HNRFI – Written Representation Harborough District Council (10th October 2023)

Appendix A

HNRFI Registration of Interest – HDC

Drawing Title
**JUNCTION 21 - B4114 /
B581 BROUGHTON ROAD
PROPOSED MITIGATION**

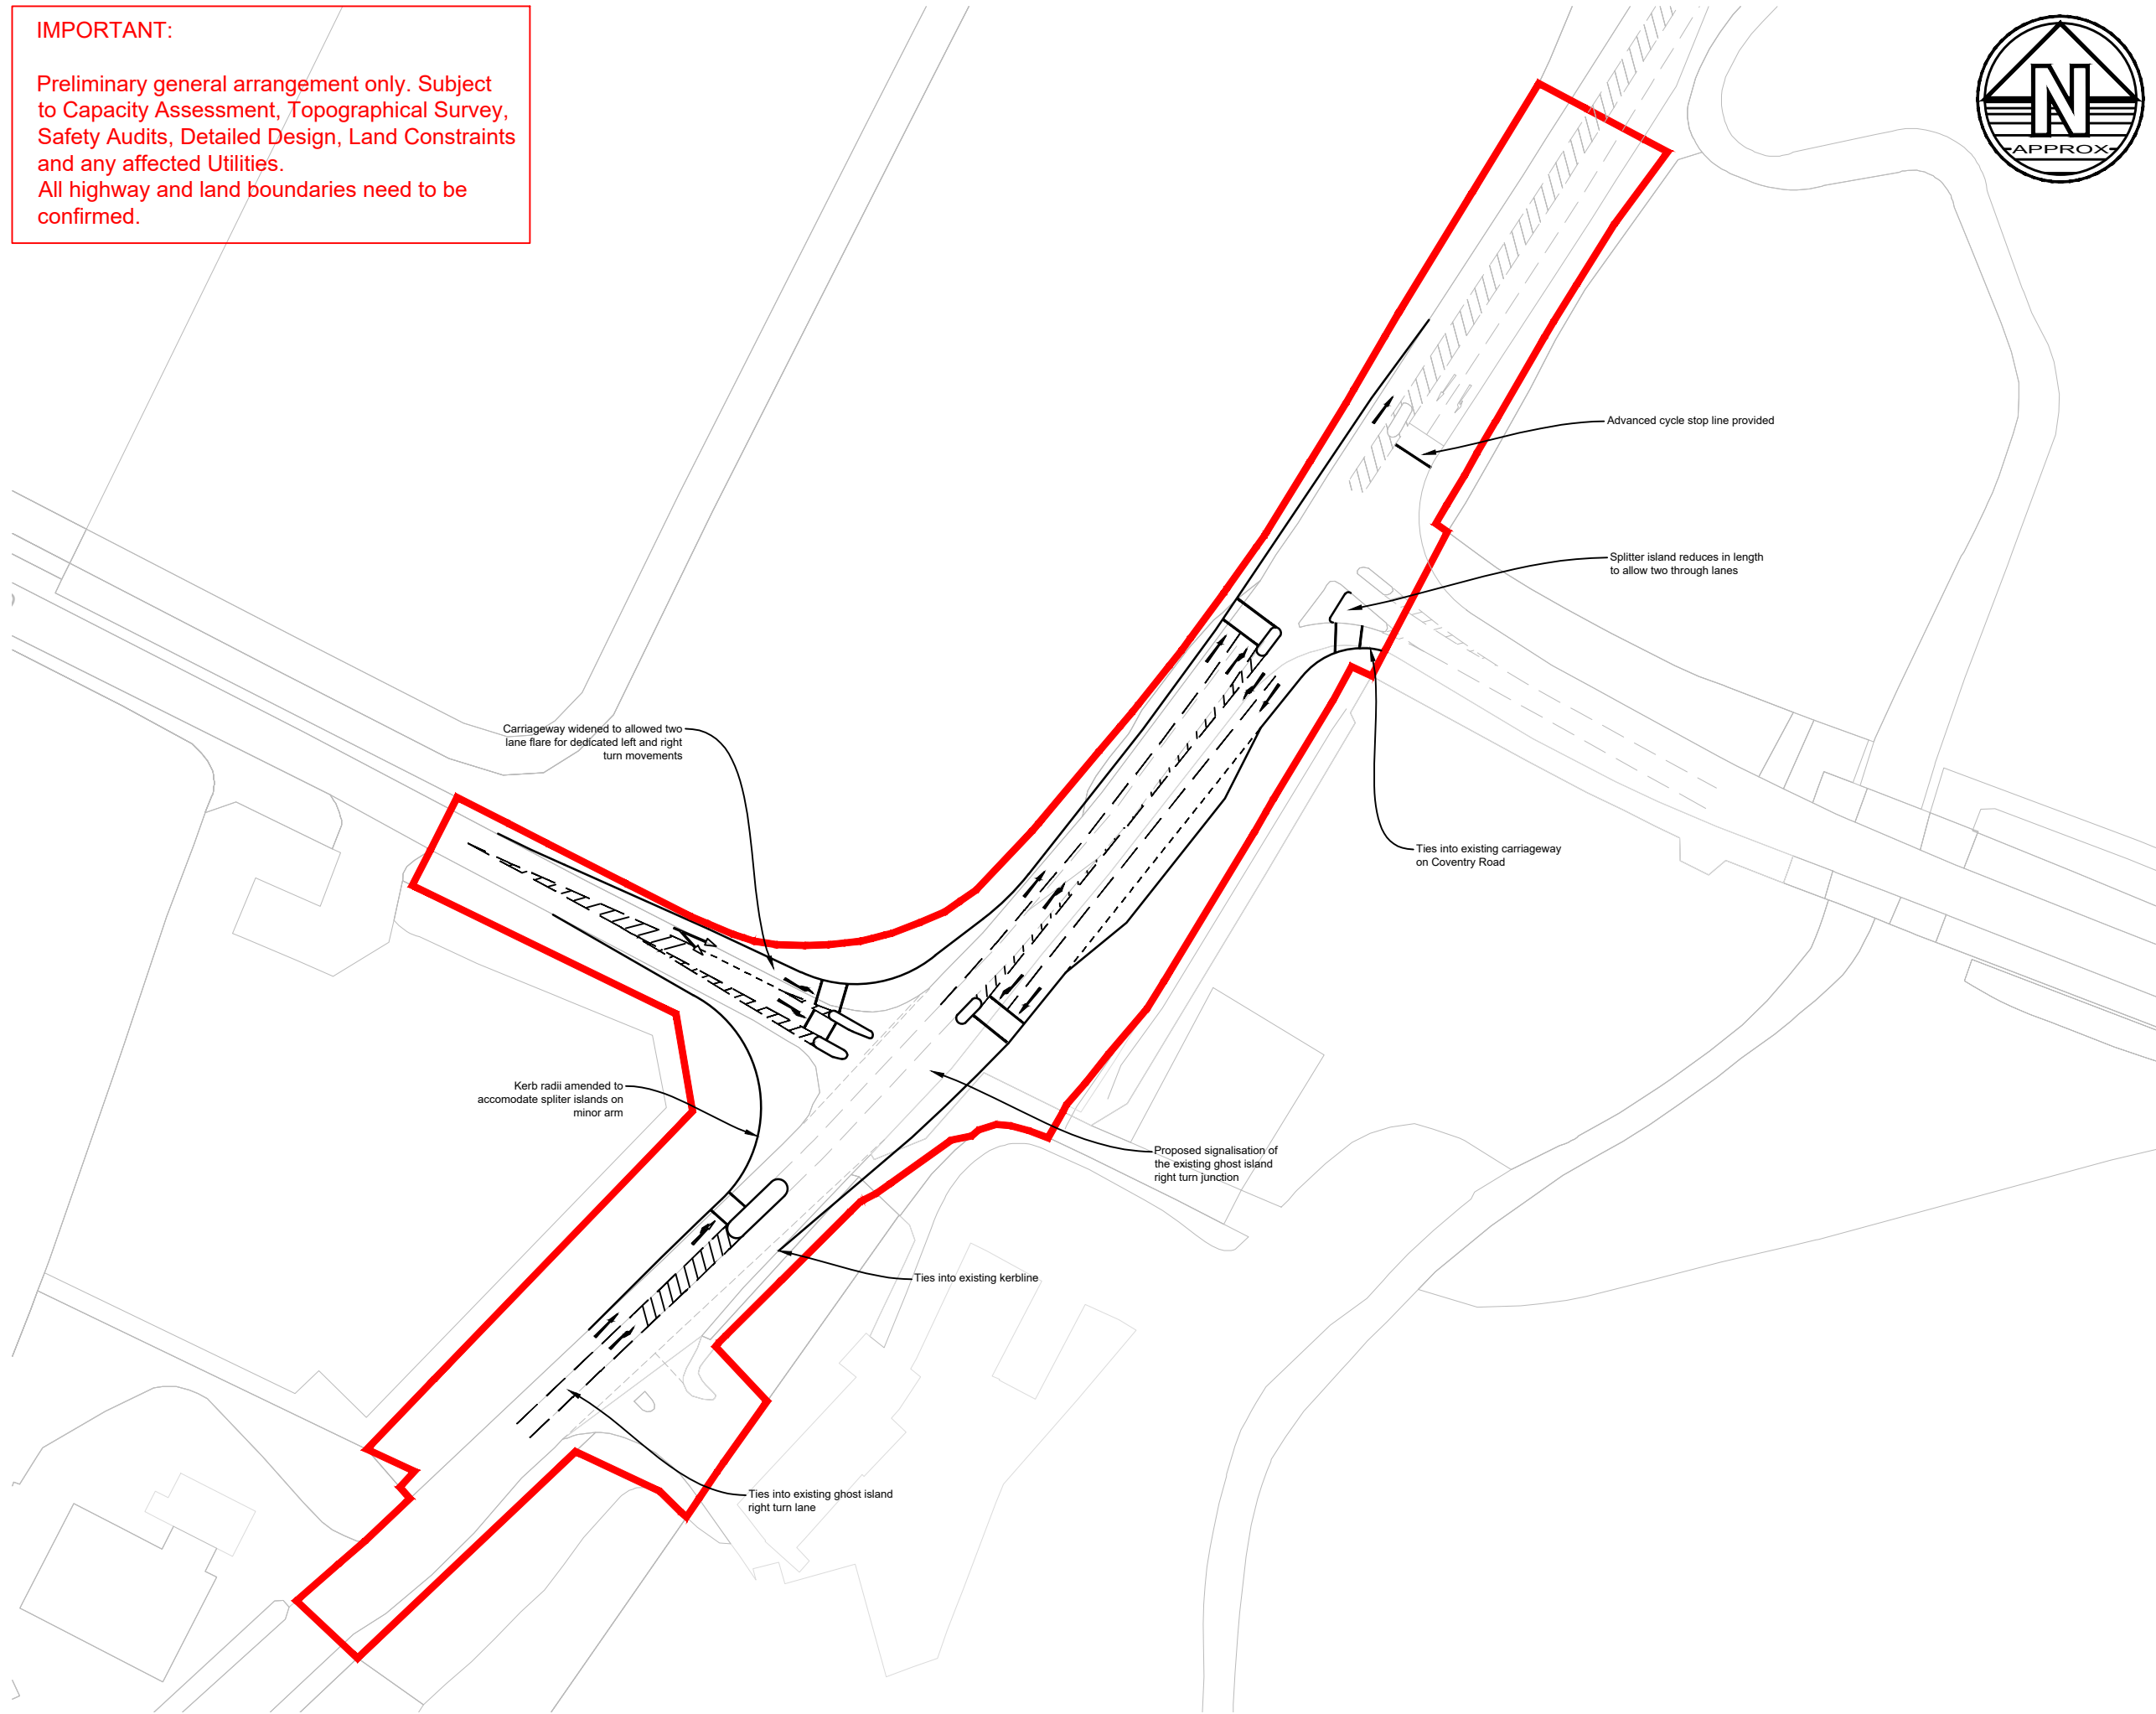
4. Highway mitigation measures in the vicinity of Broughton Astley are limited to the B4114/B581 junction, when compared to indicative proposals in the applicants earlier public consultation stages.
